Re: Railway works and all works necessary to eliminate and, where necessary, upgrade seven numbered level crossings and carry out all associated and ancillary works along a 24-kilometre section of the Dublin to Cork Railway Line.  
Fantstown, Thomastown, Ballyhay, Newtown, Ballycoskery (Ballyhea Village), Shinanagh and Buttevant, Co. Cork and Co. Limerick.

## Railway Order Application ABP Case Ref NA04.310286

**Further Observations on behalf of the Trustees of the Diocese of Cloyne in regard to the proposal by Coras Iompair Éireann (CIE) to replace the manned level crossing at Ballycoskery XC212 with a new road and overbridge.**

Figure 2.11: XC212 Ballycoskery Proposed Alignment

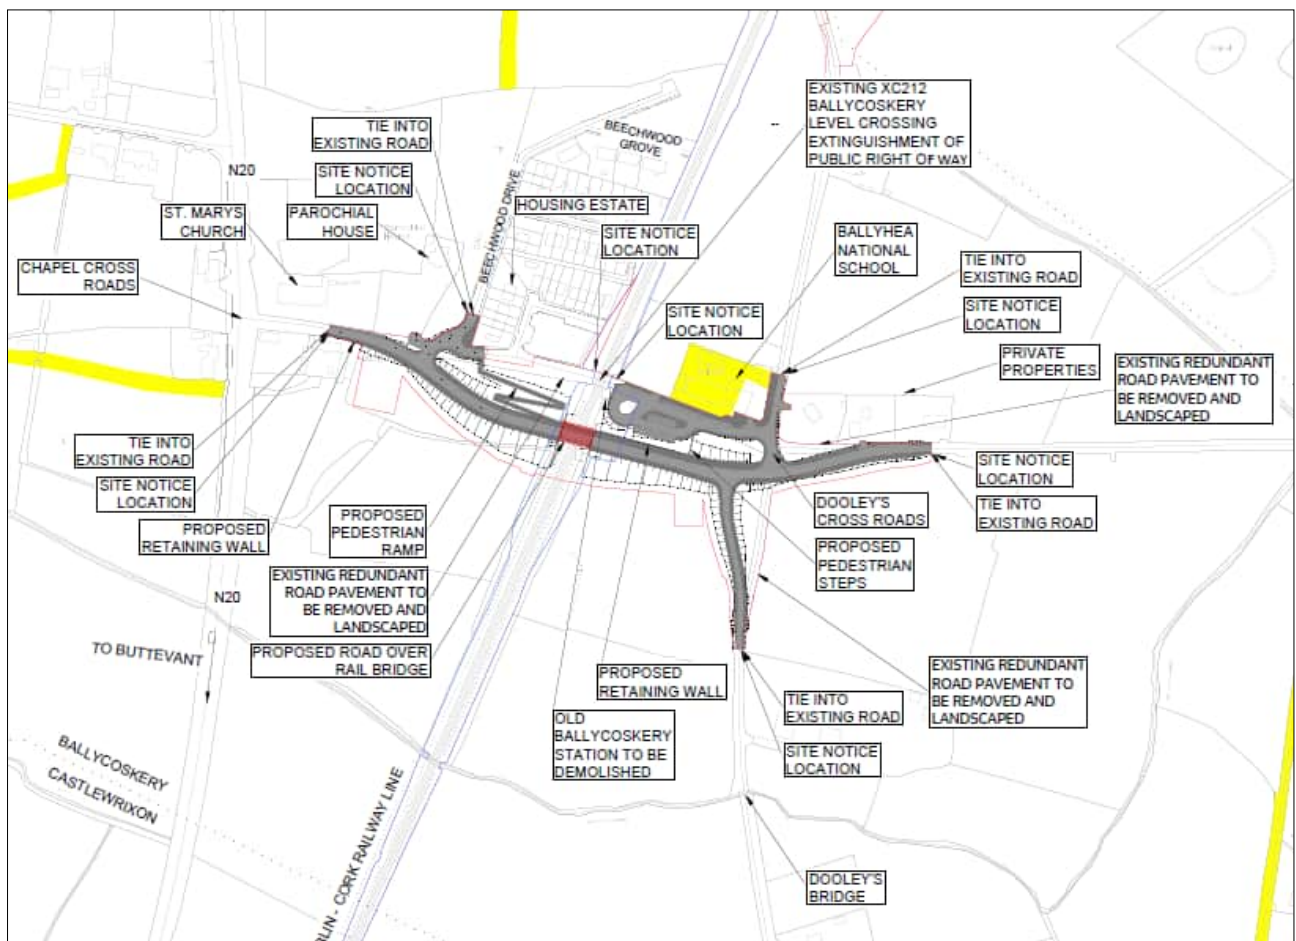
The overlap between the works proposed by CIE and the preferred M20 corridor underlines the potential for significant cumulative impacts between the two projects not only during the construction and operational stages but also in regard to the need for a coordinated approach to the design of the alterations to the local road network which would be required to facilitate both projects. There may not be any need to build a rail overbridge at the Ballycoskery crossing in Ballyhea village if the detailed design of the motorway makes provision for an alternative rail crossing further to the south.

In our opinion Chapter 17 the Environmental Impact Assessment Report fails to give due consideration to the cumulative impact on Ballyhea Village of the railway overbridge and the M20 motorway. While the 'N/M20 Cork to Limerick Road Improvement Project' was included among the projects to be assessed for cumulative impact, Section 17.4 of the EIAR states that each environmental discipline expert combined the 7 sites when assessing the cumulative impact. It appears that the overlap of the preferred M20 corridor with the works proposed at Ballycoskery crossing was overlooked while the cumulative impacts during construction was deliberately discounted on the basis that the rail works would be completed before commencement of the M20 construction programme. In our opinion these questionable assumptions undermine the conclusions reached in the EIAR.

A new County Development Plan was adopted on 25 April 2022 and will come into effect on the 6<sup>th</sup> June. During the course of the review of the 2017 Local Area Plan, a proposal to amend Objective U-01 to make specific provision for a road overbridge rather than a road realignment was rejected by the elected members. This reflects the fact that the planning authority as well as the local community are opposed to the provision of a road overbridge in the centre of the village as currently proposed by CIE.

The EIAR acknowledges that there will be significant effects on the environment but seeks to mitigate rather than to avoid these effects. The failure of the project design to avoid significant effects on Ballyhe village is primarily due to:

- (a) the exclusion of the option of a CCTV crossing at the preliminary stage
- (b) the lack of due consideration of alternative site locations, site layouts and project designs; and

- (c) the inadequate assessment of the cumulative effect with the proposed M20 even though the corridor of the preferred route actually overlaps the proposed works.

In our opinion, the criteria used for the comparative analysis of design options and for the assessment of cumulative effects did not give appropriate weight to visual character, built heritage and biodiversity and this resulted in a lower ranking for the underbridge option.

- (a) the review of the All Island Railway Strategy;
- (b) the final design and approval of the adjacent M20 project which may include alterations to the local road network which would obviate the need for an overbridge in the centre of Ballyhea village; and
- (c) the preparation of a new EIAR which would seek to avoid rather than mitigate significant effects including the cumulative effects with the final design for the M20 project.
